FAO Kathryn Hughes  
Ribble Valley Borough Council  
Council Offices  
Church Walk  
Clitheroe  
BB7 2RA

2 October 2024

## **Non-Material Amendment Application to planning permission 3/2022/0537: Land adjacent to Northcote Road, Langho BB6 8BG**

**PLOT 1 BIRCH**  
4B8P Detached - Proposed Floor Plans

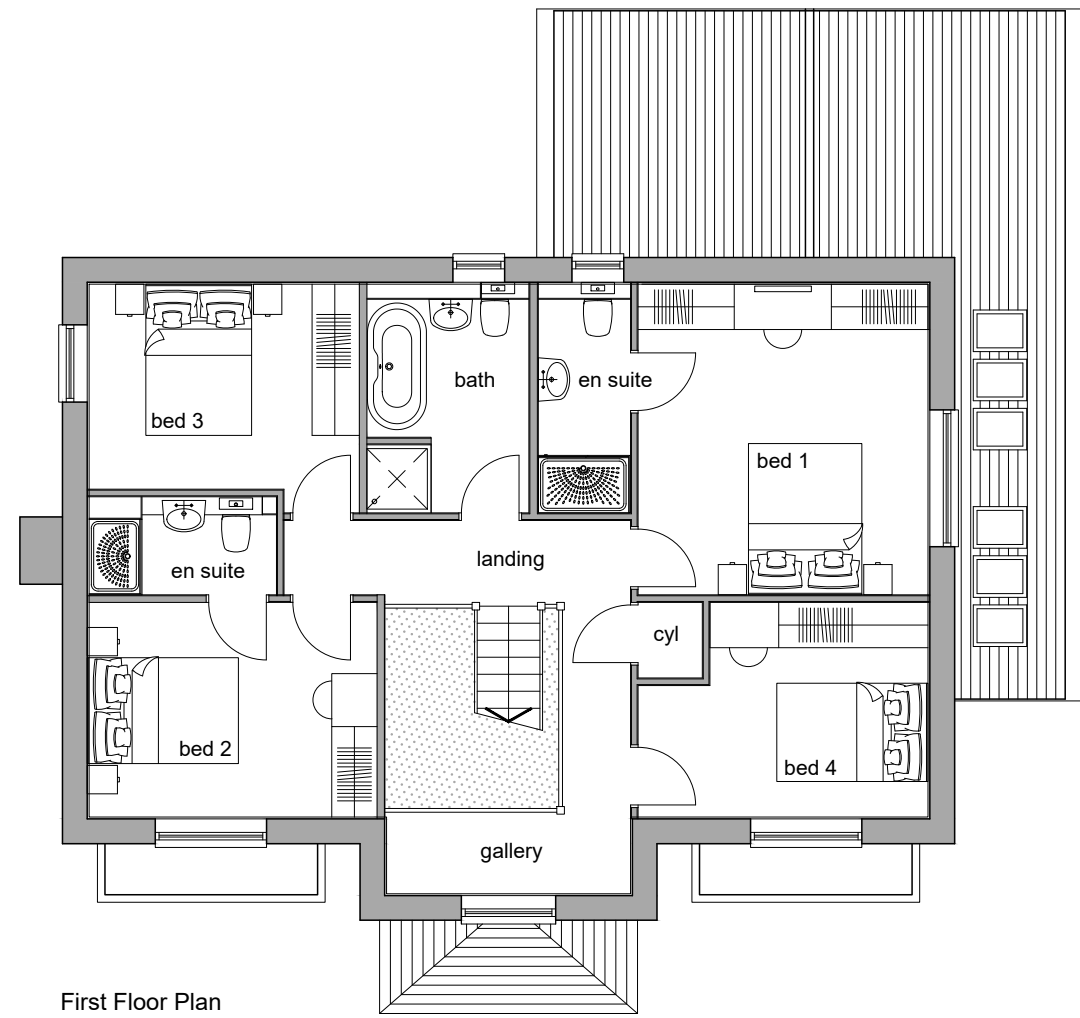
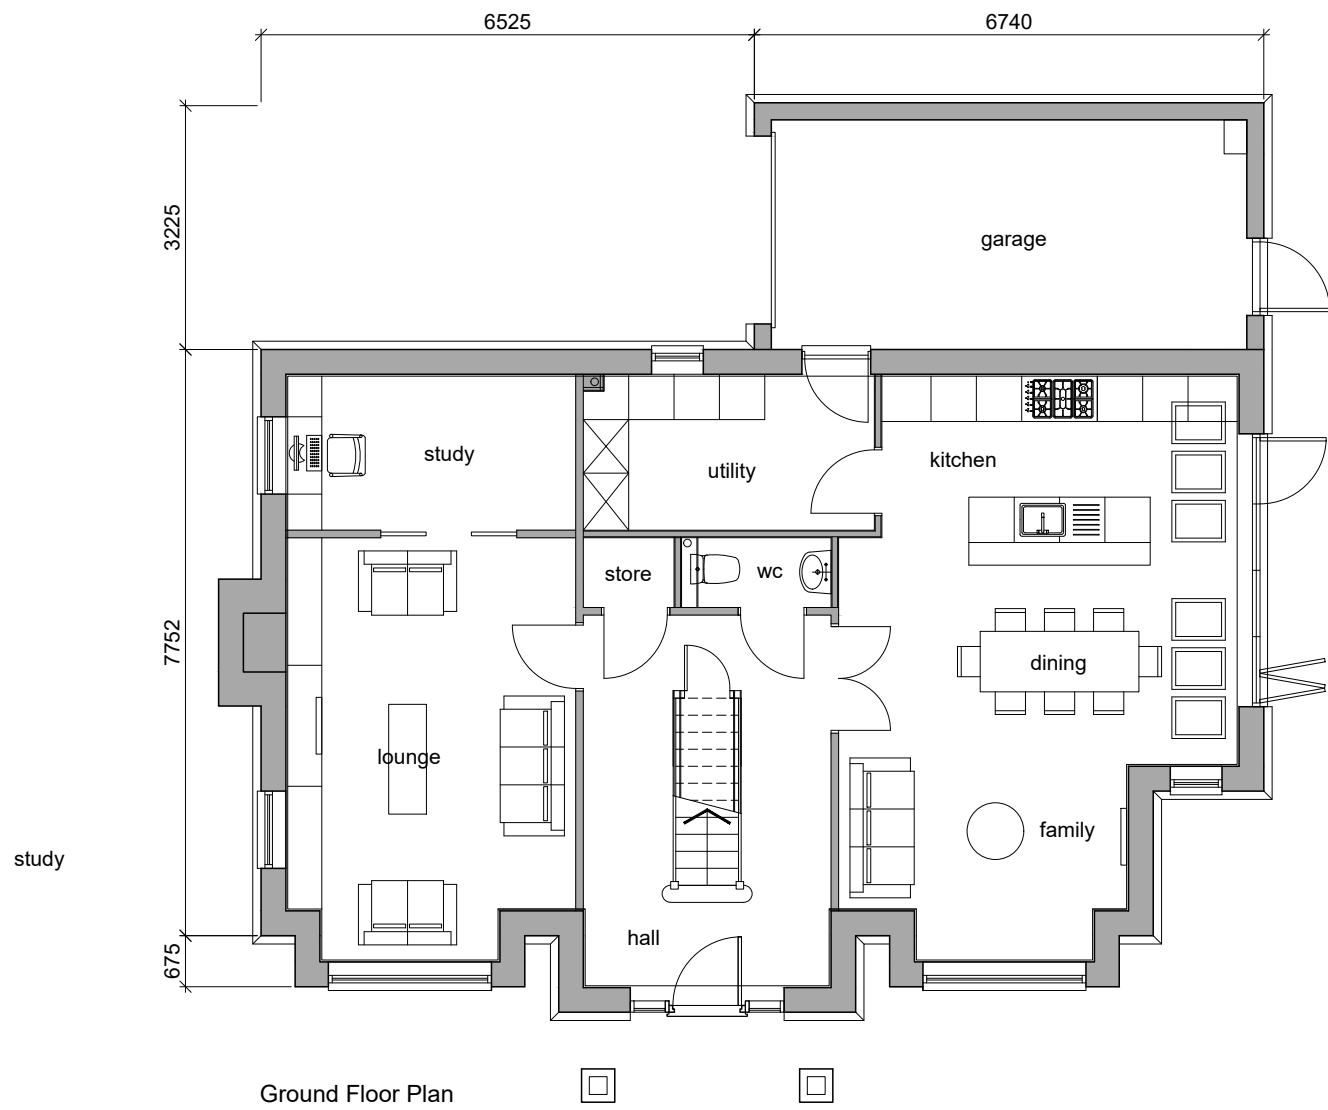
- Minor alterations to the internal layout of the properties, to include:
  - Addition of a ground-floor study within Units 1 and 3
  - The inclusion of en-suite bathrooms to bedroom 2 within Units 1- 7.

- Unit 1: Omission of side window to bedroom 2 and additional front-facing window to dining area.
- Unit 7: Additional dining area window added to front elevation.

**PLOT 2/4/6 HOLLY**  
4B8P Detached - Proposed Floor Plans

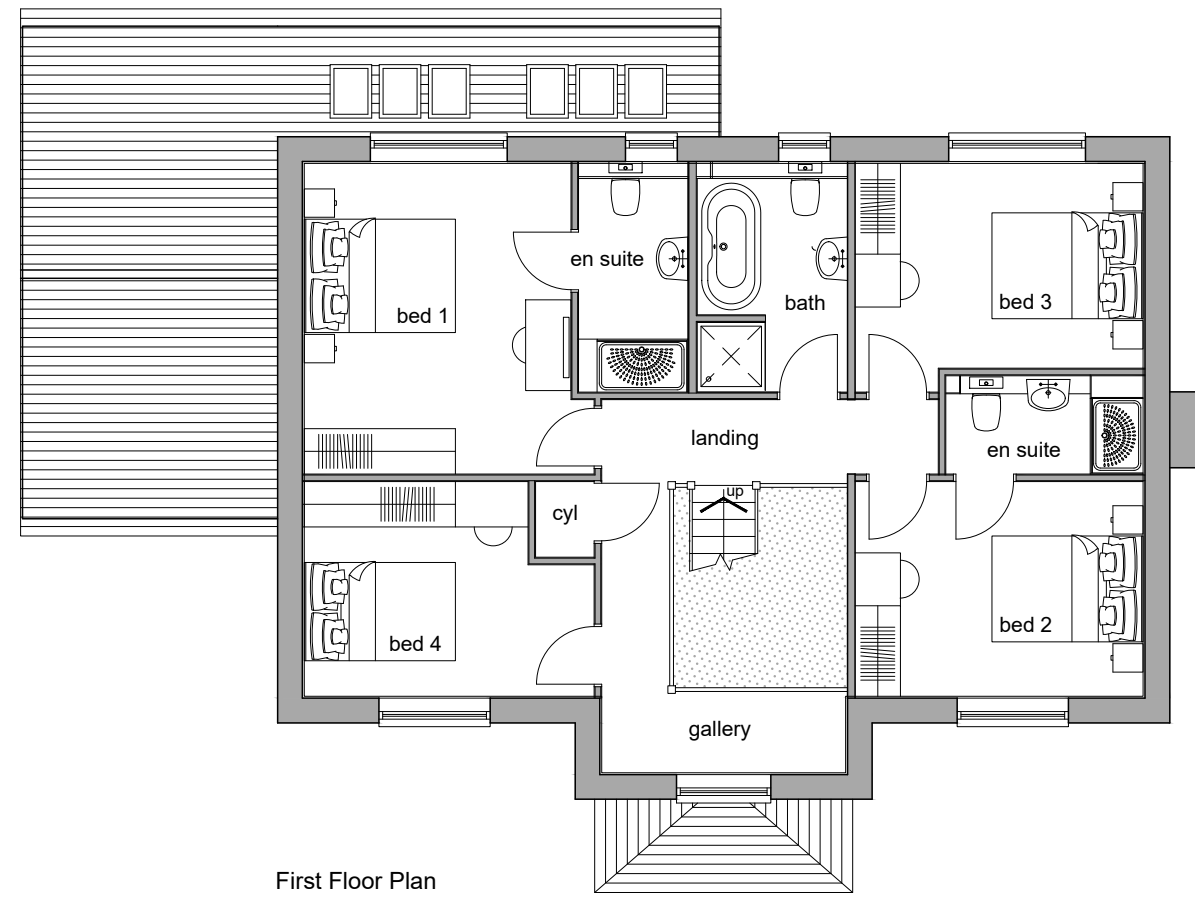
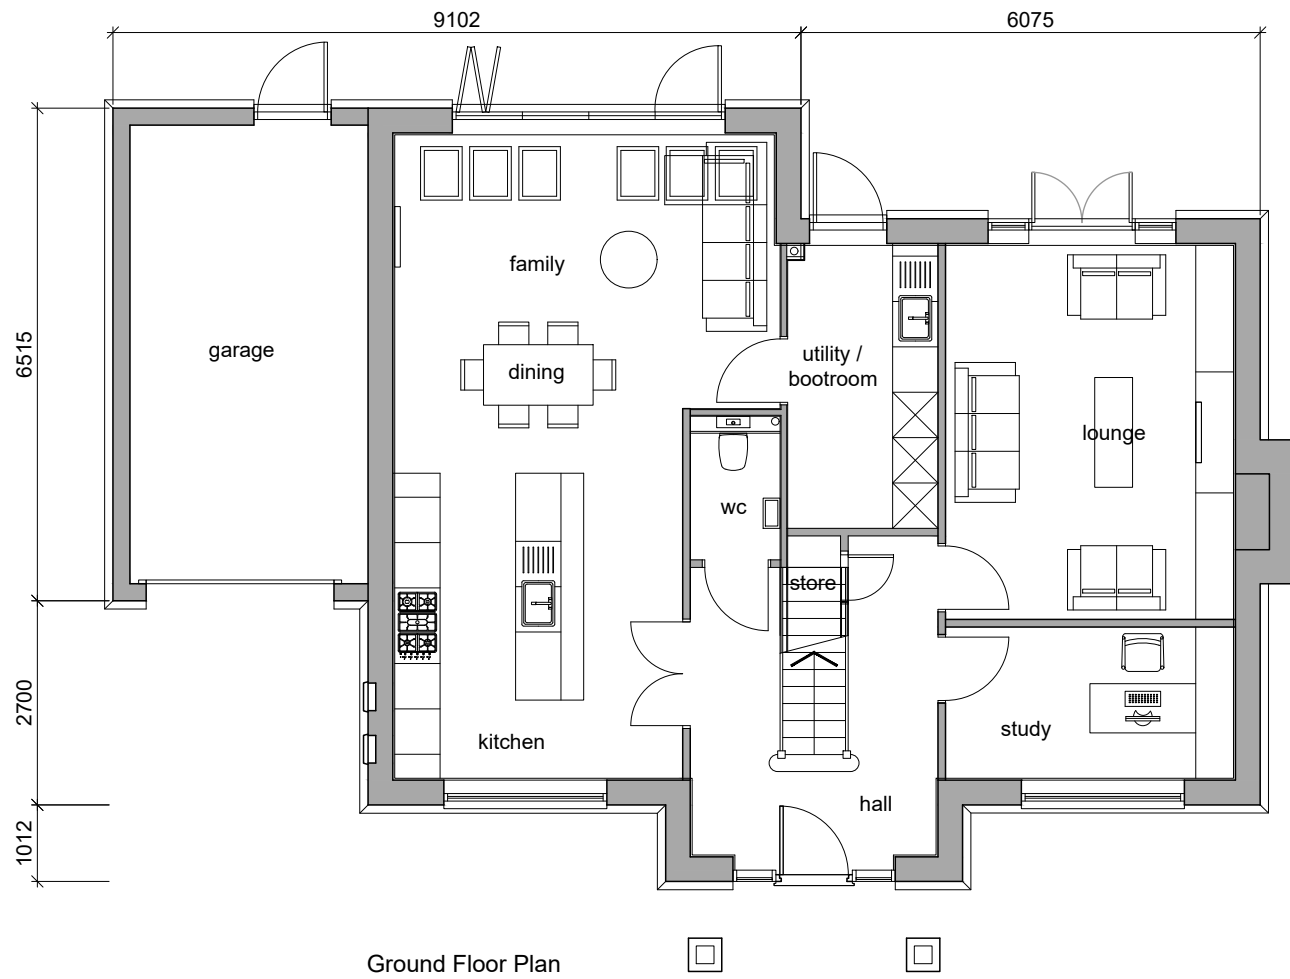
- Feature chimneys added to all properties.
- Addition of an en-suite window on gable elevation of Units 2, and 4-6.
- Traditional canted bays adjusted to contemporary square-edged bays.

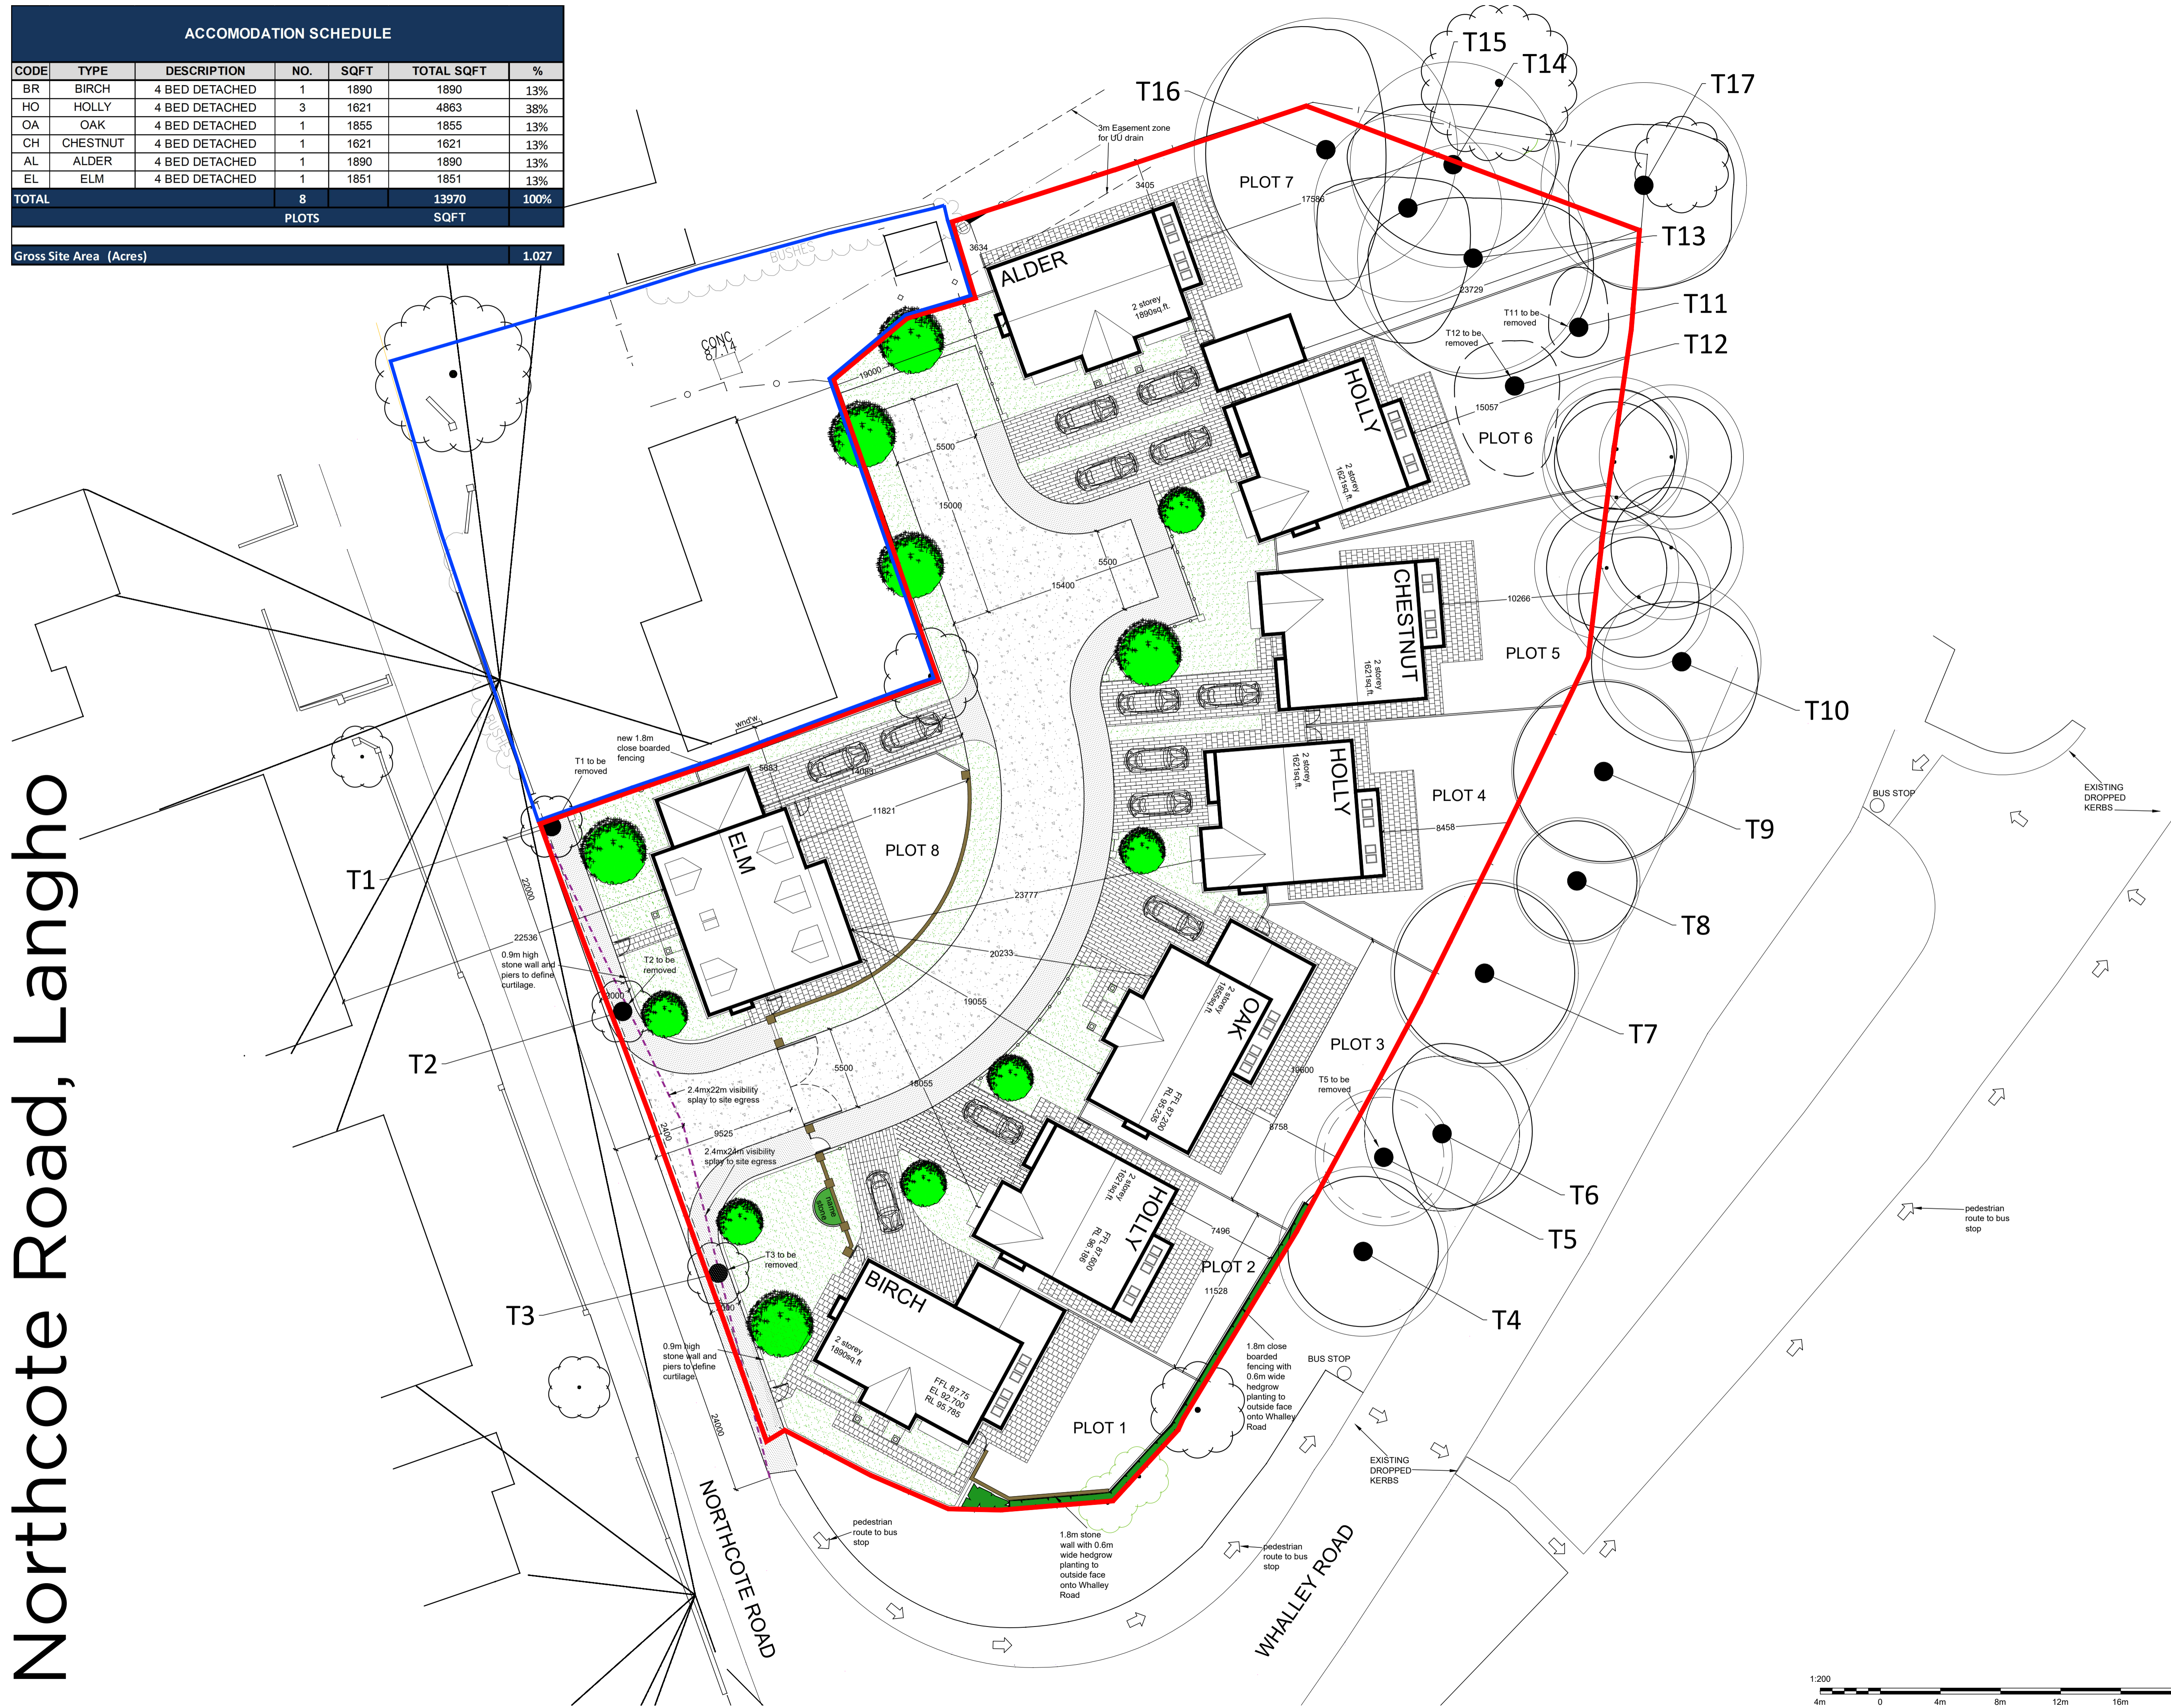
- Unit 8: An adjusted eaves line and removal of its canted bay. Increased footprint (4.2sqm) to ground-floor to create a more usable kitchen / dining area.

As described above, the ground-floor footprint to Unit 8 has been increased by a small amount (4.2sqm) to create a more useable kitchen / dining area. This results in a 2.5% increase in the floor-space associated with this property, which is not considered to be a material uplift. This figure becomes even more negligible, when considered in the context of the overall development. Furthermore the enlargement to Unit 8 will not be perceptible from surrounding streets and it will not change the design ethos previously approved as part of the Consented Scheme.
